RE: 4338 Old stage road north,Angier

Dee,
These are the issues I see with the plan. I used a combination of the plan you marked up, plus the plan you sent.

**Main Floor Plan**  
 Scale: 1/4" = 1'-0"

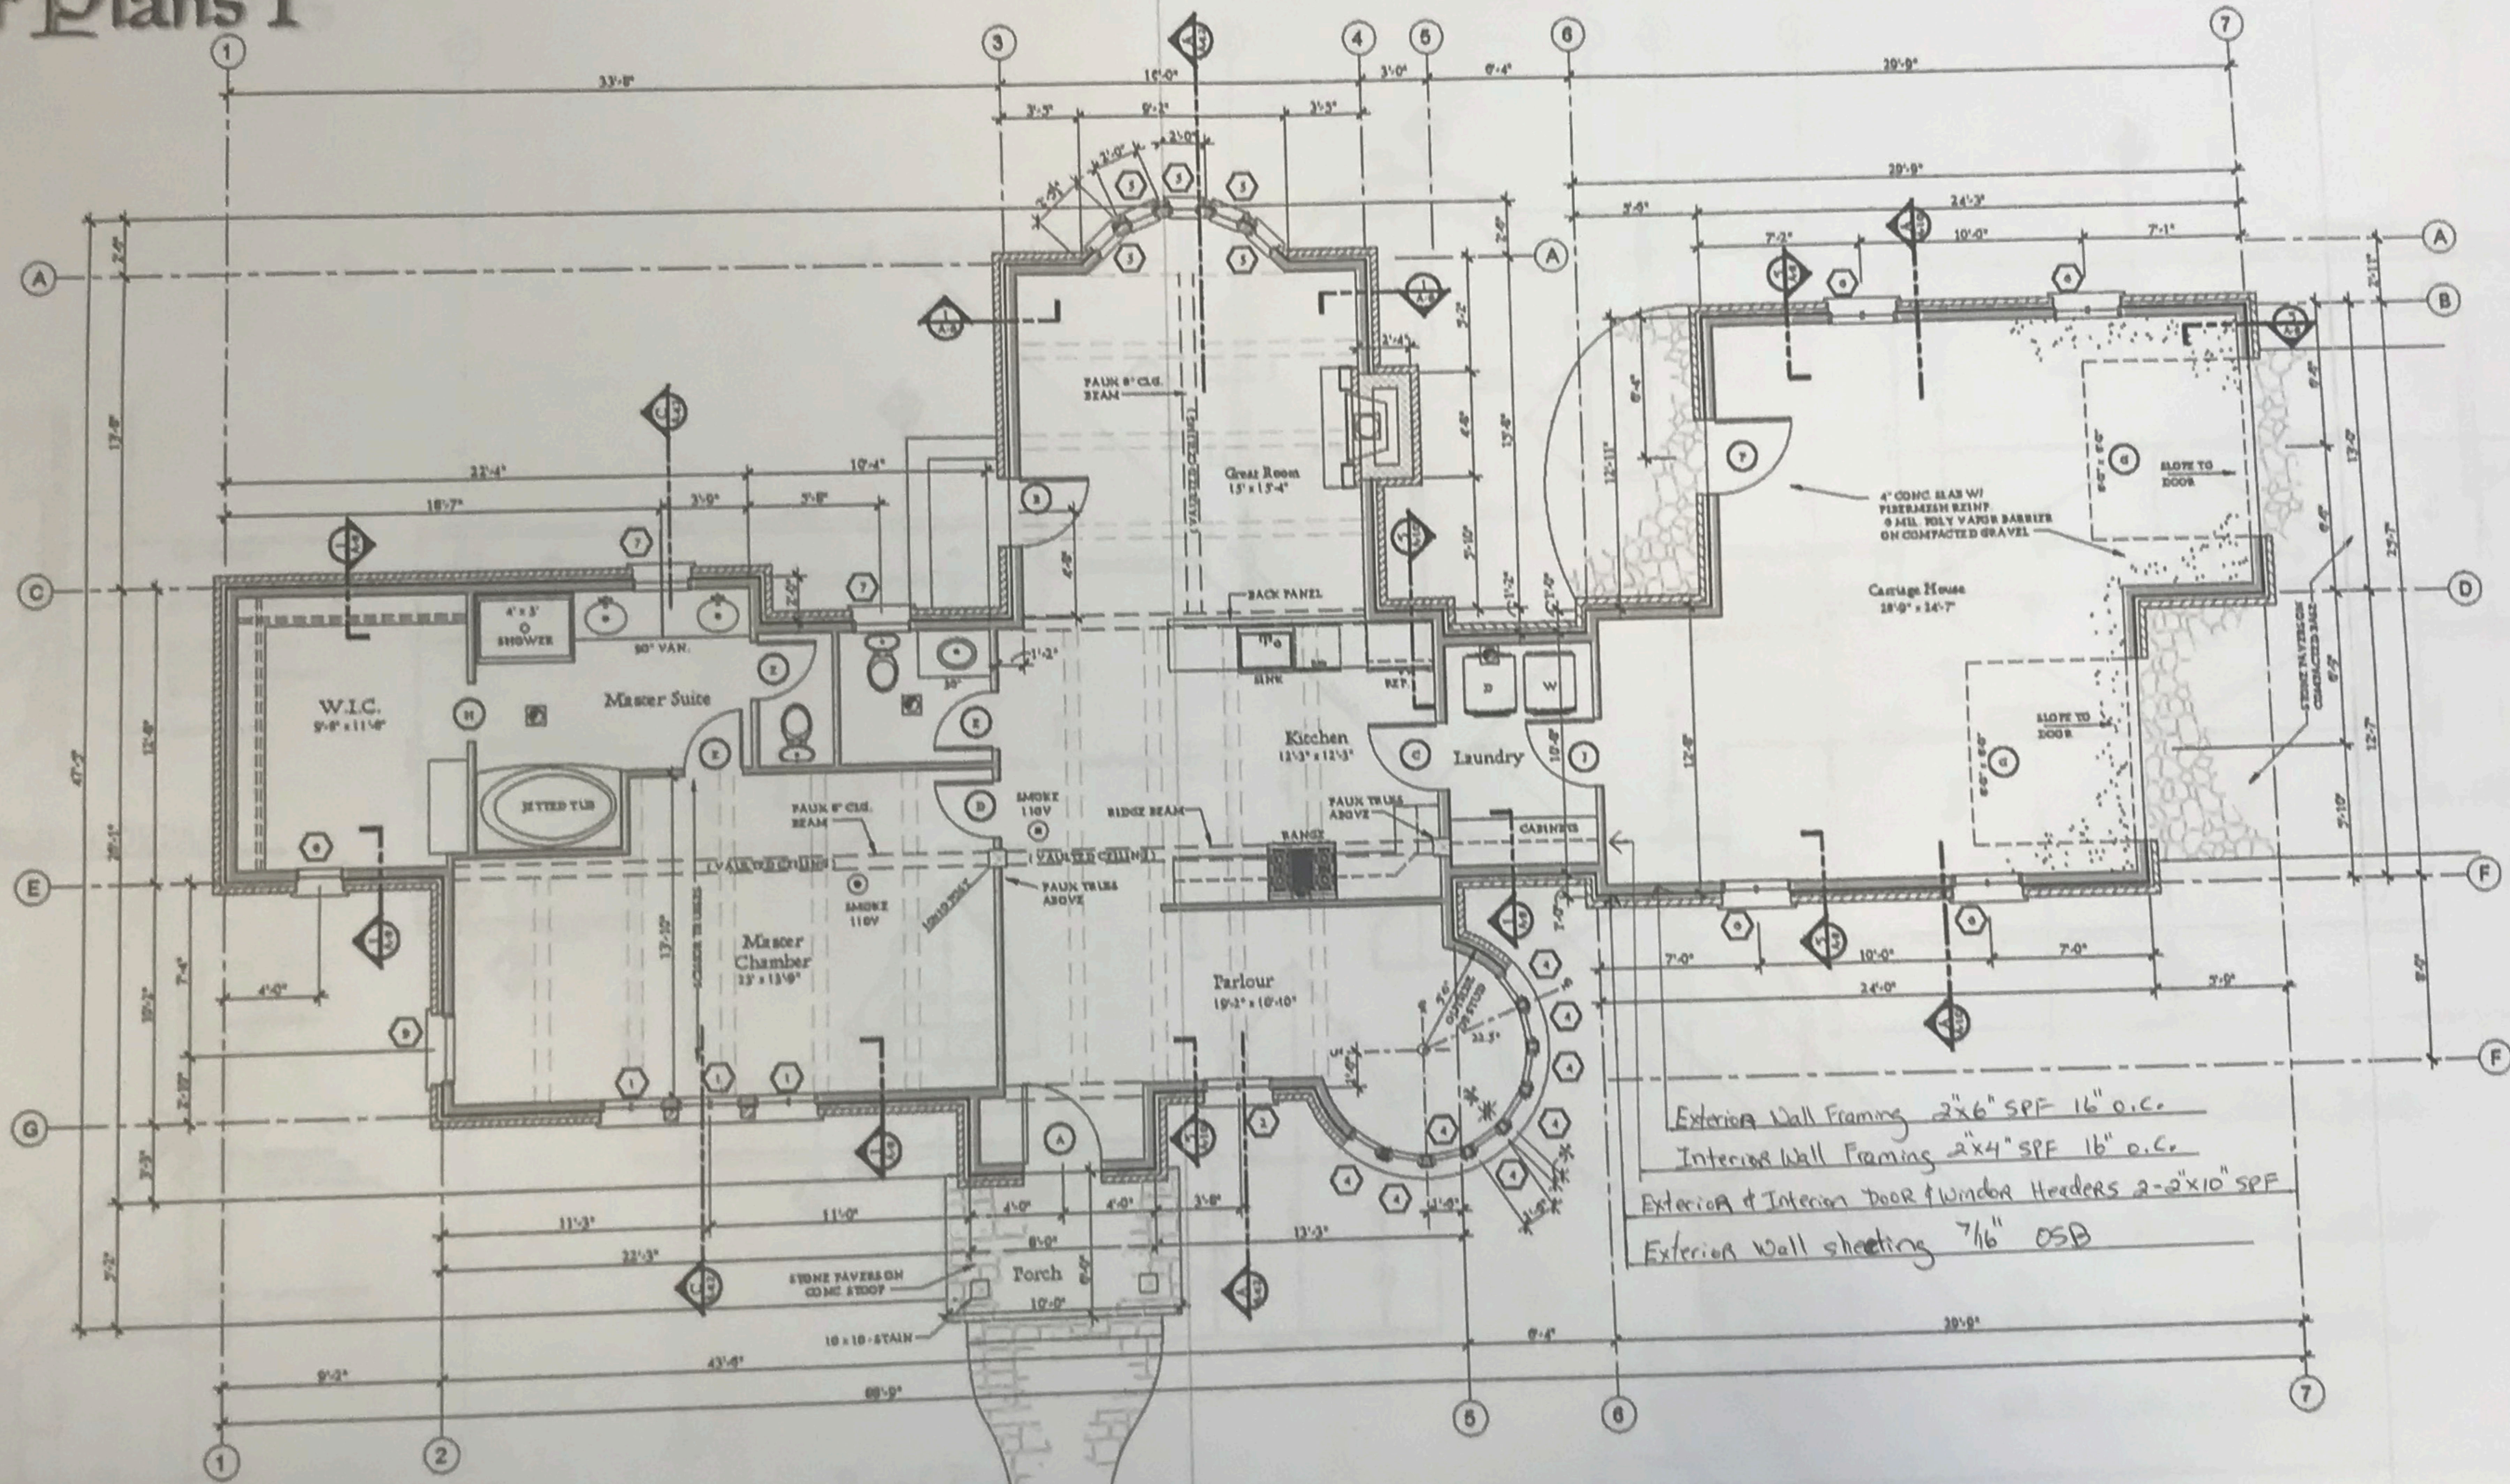
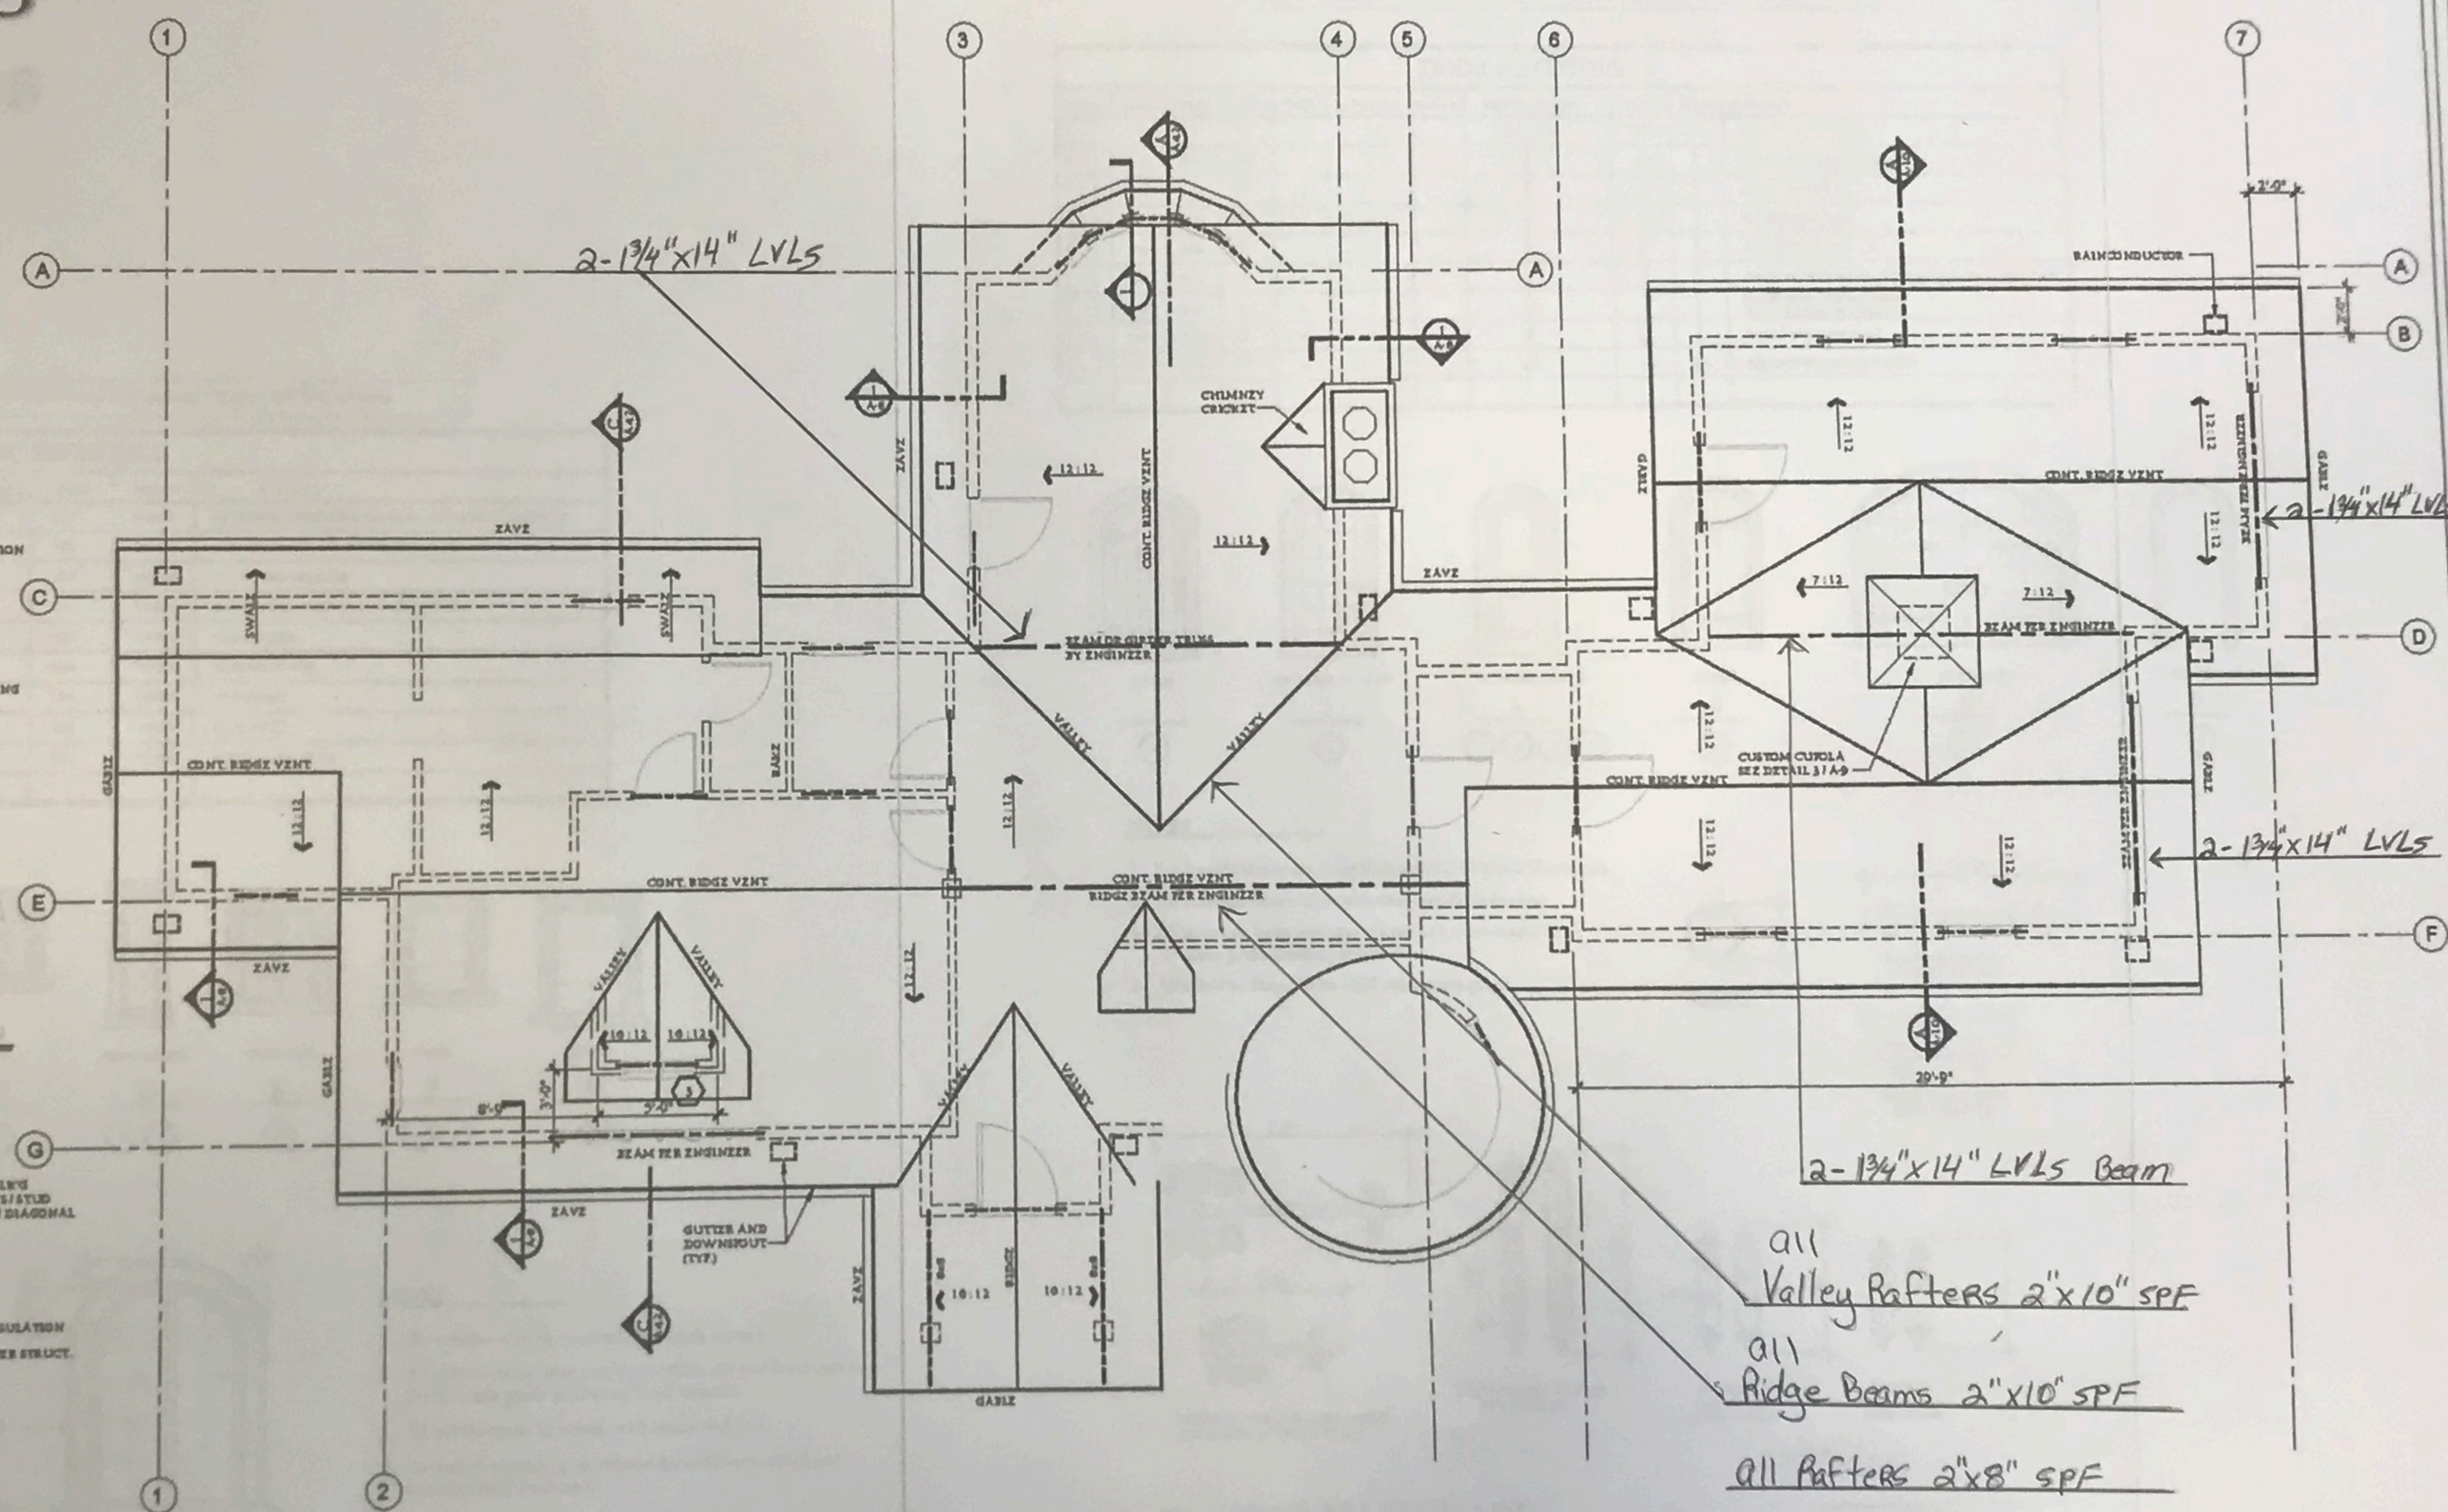
1. Floor joists over spanned through parlor/kitchen/great room.
2. All vaulted ceilings must have ridge beams (typically LVL)
3. No ceiling layout for flat ceilings?
4. Need calculation cutsheets for all LVLs from supplier to verify loads/footing sizes.
